KITTITAS COUNTY

MEMORANDUM

TO: Community Development Services
FROM: Taylor Gustafson, Environmental/Transportation Planner
DATE: March 15, 2019
SUBJECT: Brightside Event Center CU-19-00002

Site Map

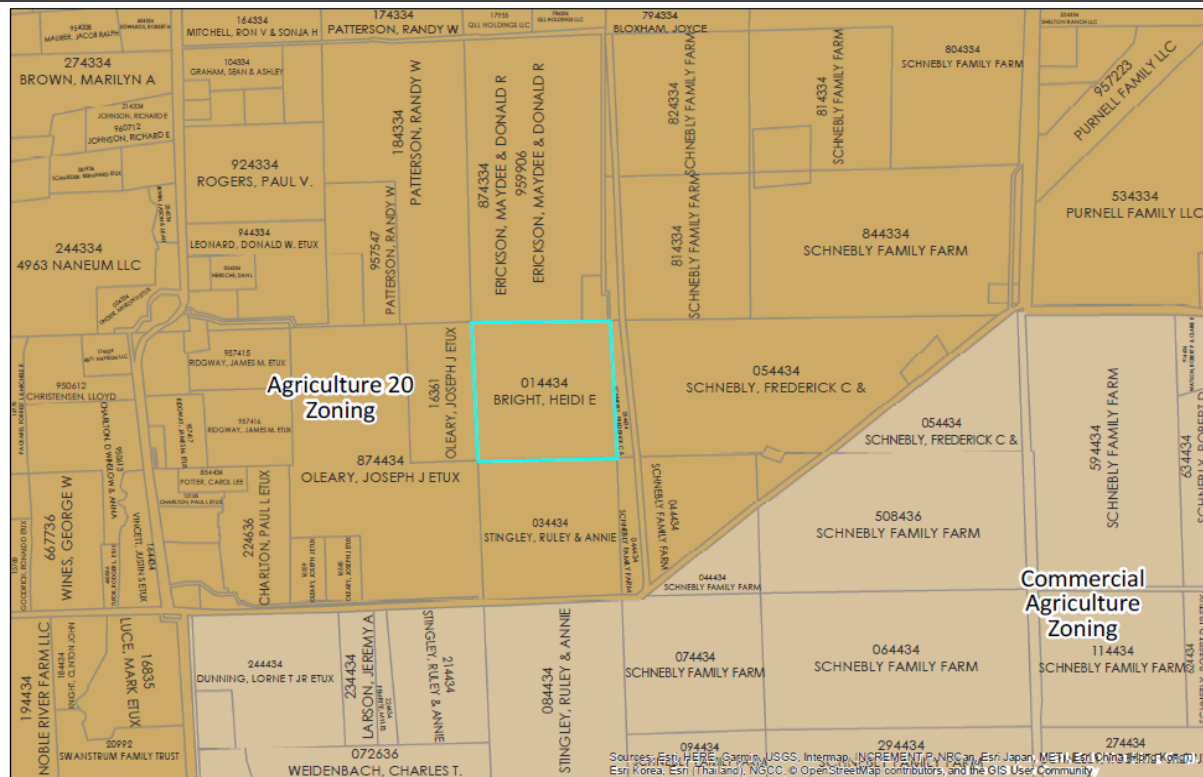
1. It appears that the proposal creates greater than 5,000 square feet of new impervious area. A stormwater plan meeting the requirements of the Stormwater Management Manual for Eastern Washington, current edition; is required.
2. A transportation concurrency application is required for the proposal.
3. No parking in County Right of Way is allowed associated with any activity of the conditional use.
4. A grading permit is required if more than 100 cubic yards of material are excavated from the site or imported onto the site.
5. The new proposed access shall meet all requirements of Kittitas County Code Title 12.

6. Access Roads will need to meet Kittitas County Code Chapter 12 and International Fire Code appendix D requirements.
7. Fire Apparatus Turn Around to be constructed to International Fire code Appendix D Hammerhead requirements at the location where it terminates at an outbuilding as approved by the Fire Marshal, so long as no parking anywhere on or along the driveway in and the drive to the right and left takes place.
8. No event parking will be allowed on the County Right of Way.
